Re: Flying Horse North Filing No. 4 Preliminary Acceptance Punchlist Items

A Redlined As-built set of Construction Drawings sealed and stamped by a licensed Colorado Professional Engineer has been supplied to the County for review as a part of this filing's request for preliminary acceptance. The content below are the supplied construction punchlist items as developed by DPW and Stormwater via a walk-through completed on June 9, 2026. The Developer has since remediated and proposed acceptable alternatives approved by the Engineer of Record to satisfy the County's listed requirements. Responses are provided below after each listed item.

SHEET PND	21
--------------	----

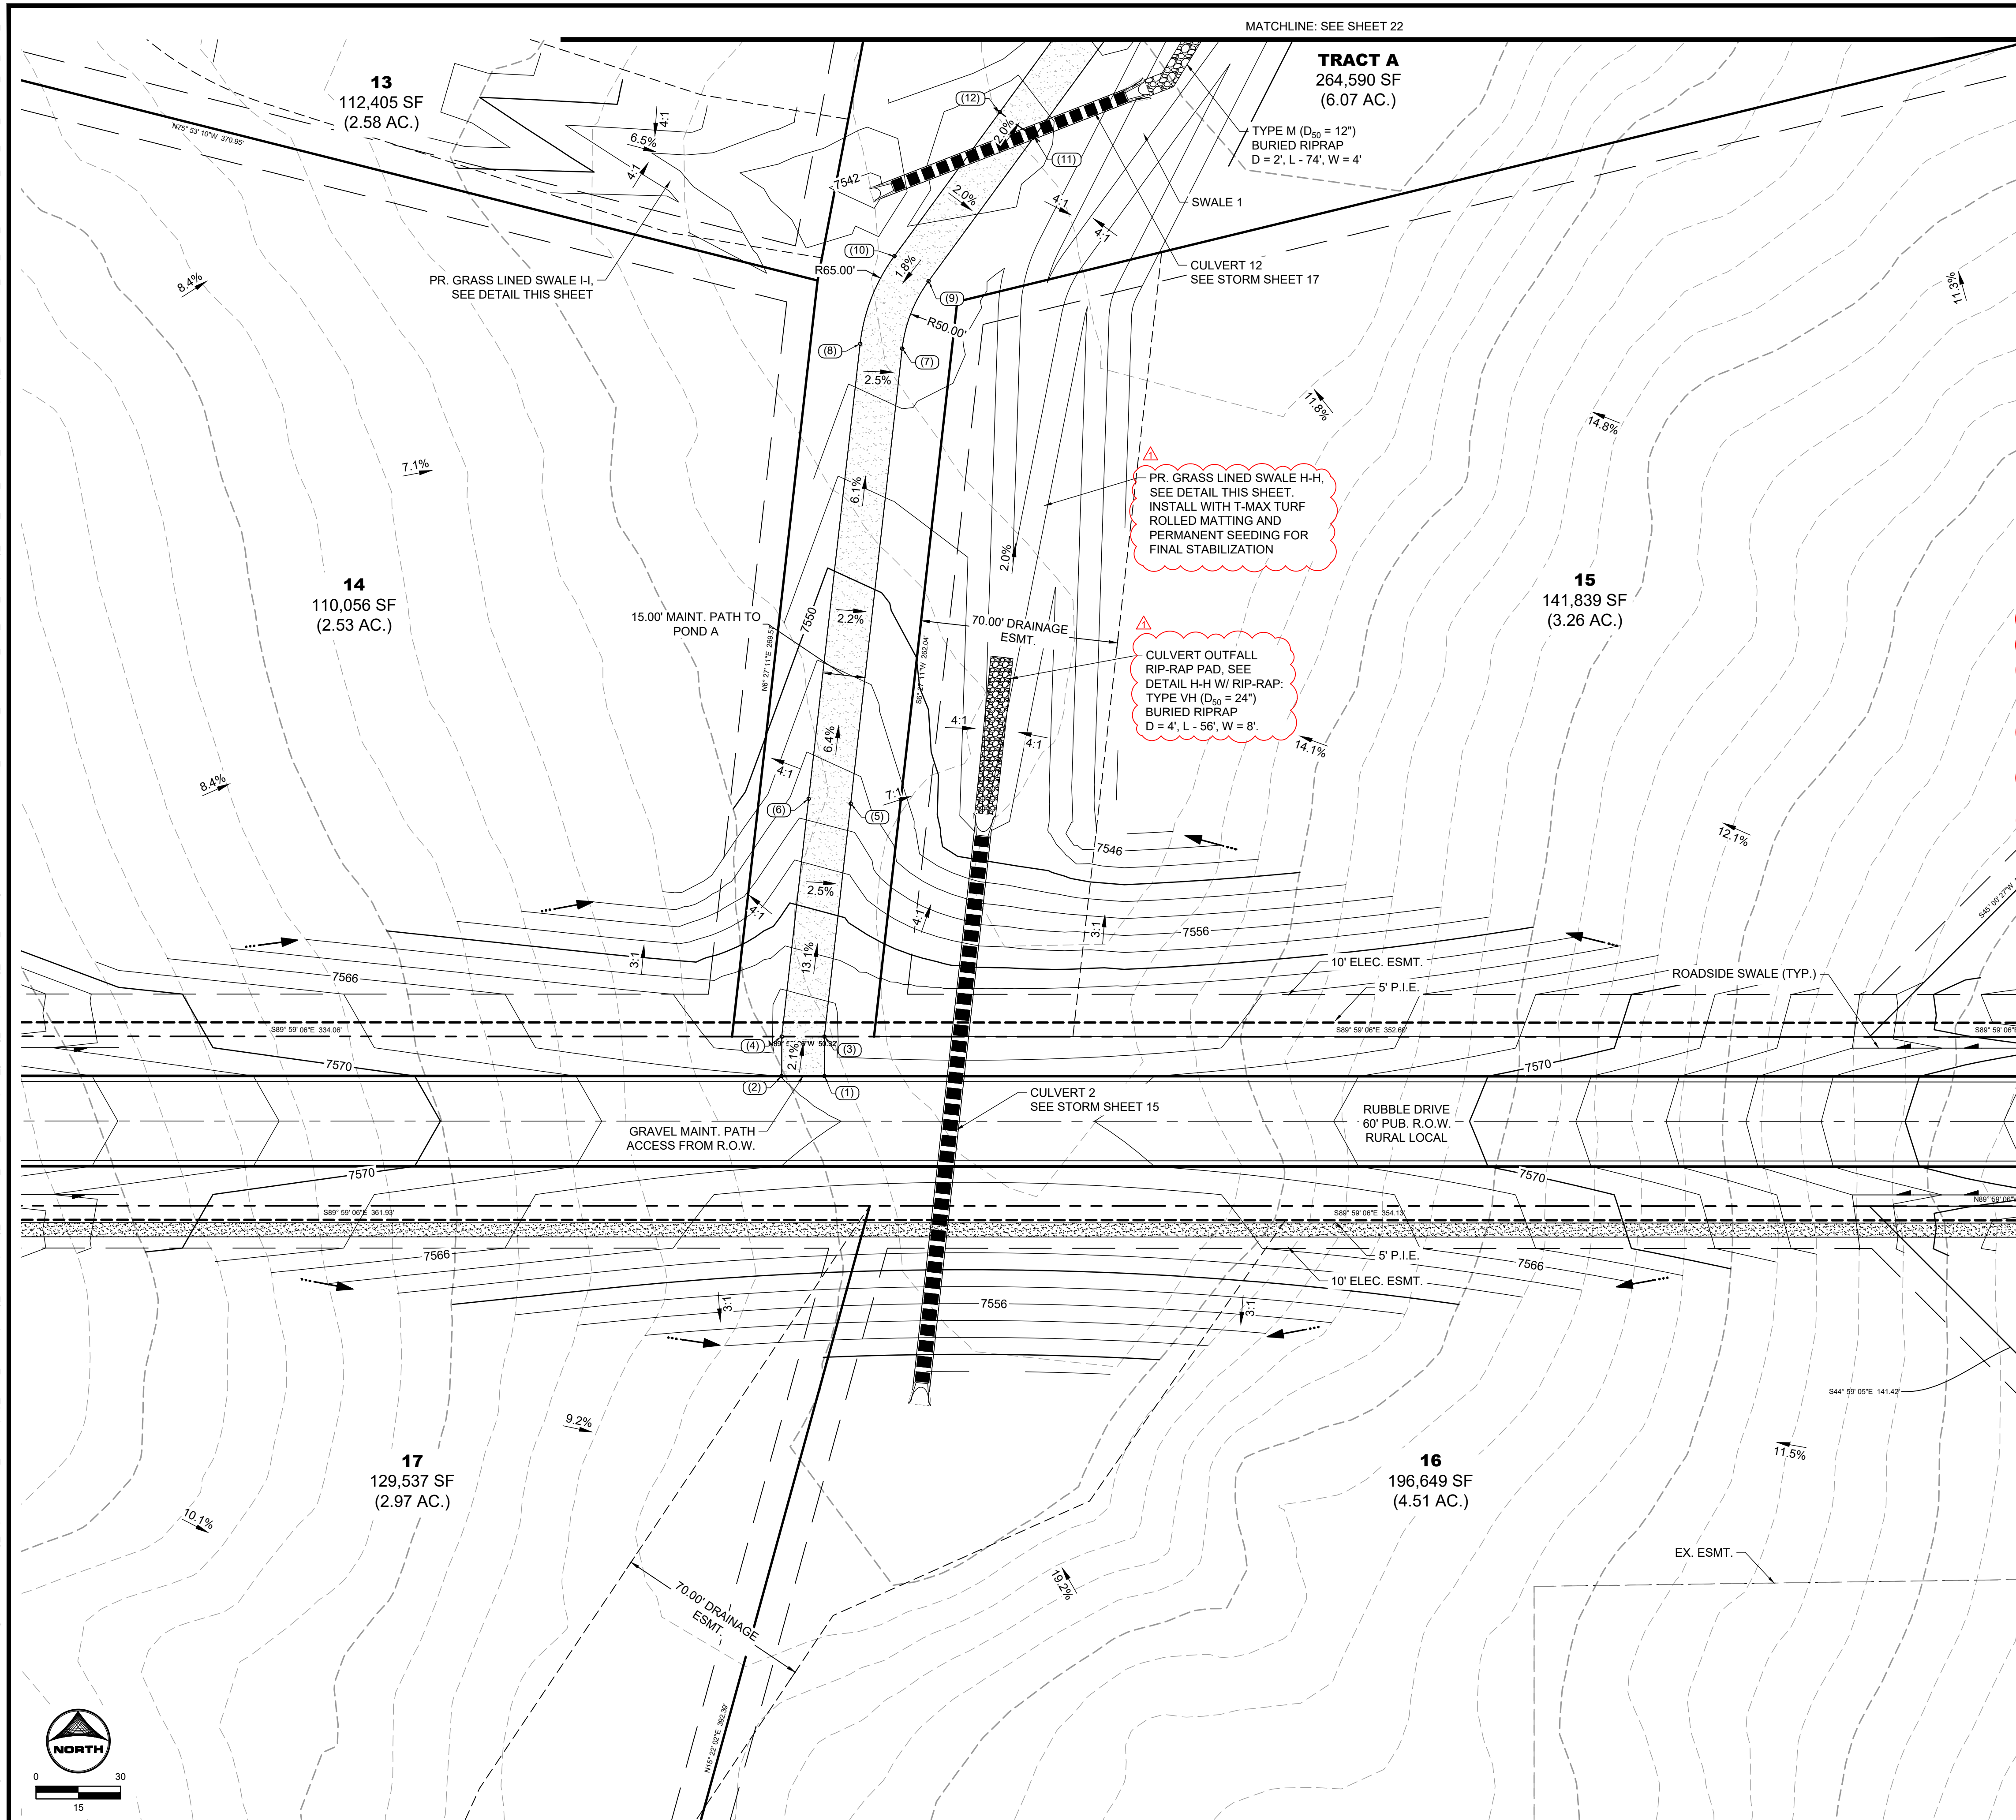
- Inflow Riprap Upstream of Forebay
 - The riprap inflow is inundated with sediment and is not installed per the approved plans. Buried riprap is shown on the approved plans. Install per approved plans or consult the Engineer of Record. See Note 1. **All exposed rip-rap is now buried soil rip-rap with top soil and permanent seeding for stabilization.**

- Also, the riprap has no low-flow conveyance, such that as it has accumulated sediment in the middle of the width, the flows have been pushed to the outside of the riprap and is eroding around the sides of the riprap. Installing riprap with a V shape (per plans) or U shape would better prevent flows from causing erosion of the swale side slopes, and/or install riprap on side slopes. **A more defined V-shaped swale has been constructed. The rip-rap pad is revised per the as-built redlines and the remaining channelized section is TRM lined with permanent seeding for stabilization.**

- Outfall Riprap
 - Outfall riprap is not installed per the approved plans. Plans show buried riprap and in the field it is installed as exposed riprap. Install per approved plans or consult the Engineer of Record. See Note 1. **Outfall/spillway rip-rap is exposed rip-rap and is now reflected on the as-builts, as approved by the Engineer of Record.**

- Also, the riprap apron is not shaped to convey flows. It is piled up such that there is no positive drainage and flows will just bypass the riprap and cause erosion. So please reconfigure riprap to properly convey flows. ***A more defined conveyance V-shape swale has been constructed.***
- Maintenance access road installed with crushed concrete, which per direction from CDPHE is not an acceptable means of Final Stabilization, nor was that material on the approved plans, so please remove and install access road material per plans. ***As-built plans and redlines now call out crushed concrete as approved by the Engineer of Record. This was discussed with Stormwater staff in July 2026 and is to be allowable for this filing.***

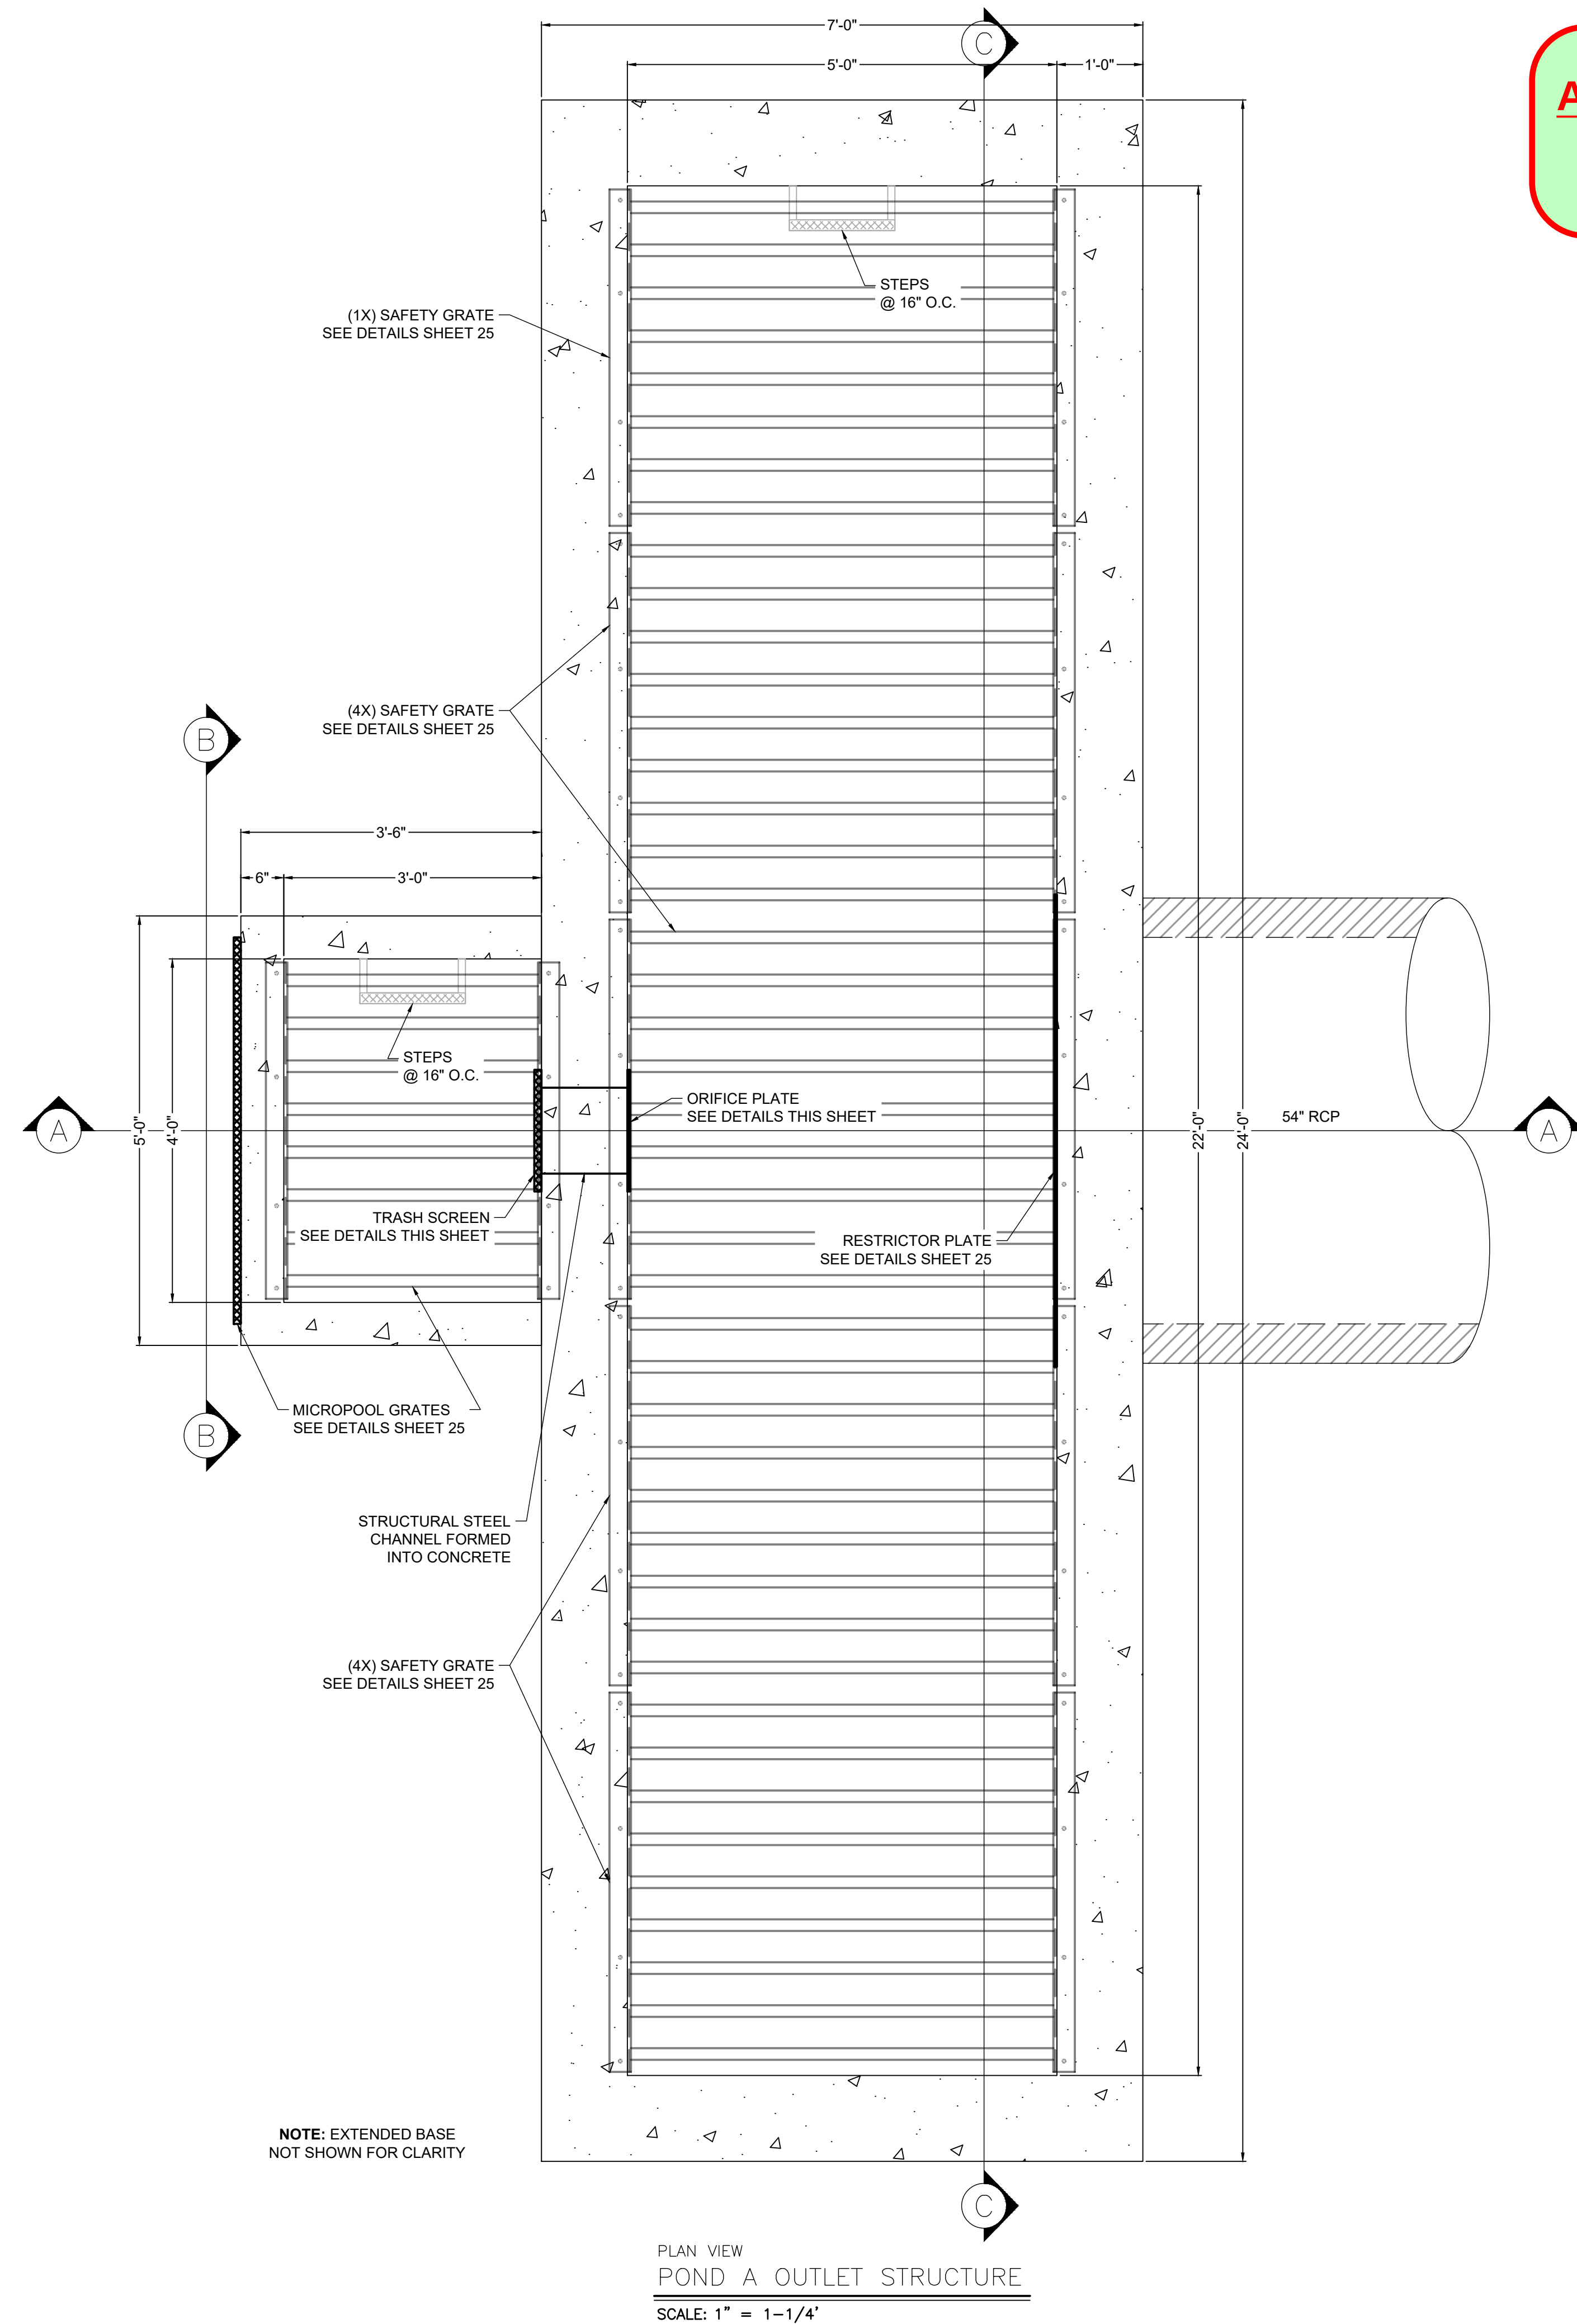
- The distance between orifice holes is not installed per the approved plans. The holes are 12in apart and should be 10.8in apart. Install per approved plans or consult the Engineer of Record. See Note 1. **As-built redlines supplied to reflect the revision to the orifice plate. MHFD Detention calculations supplied with the Pond Certification letter support the change.**
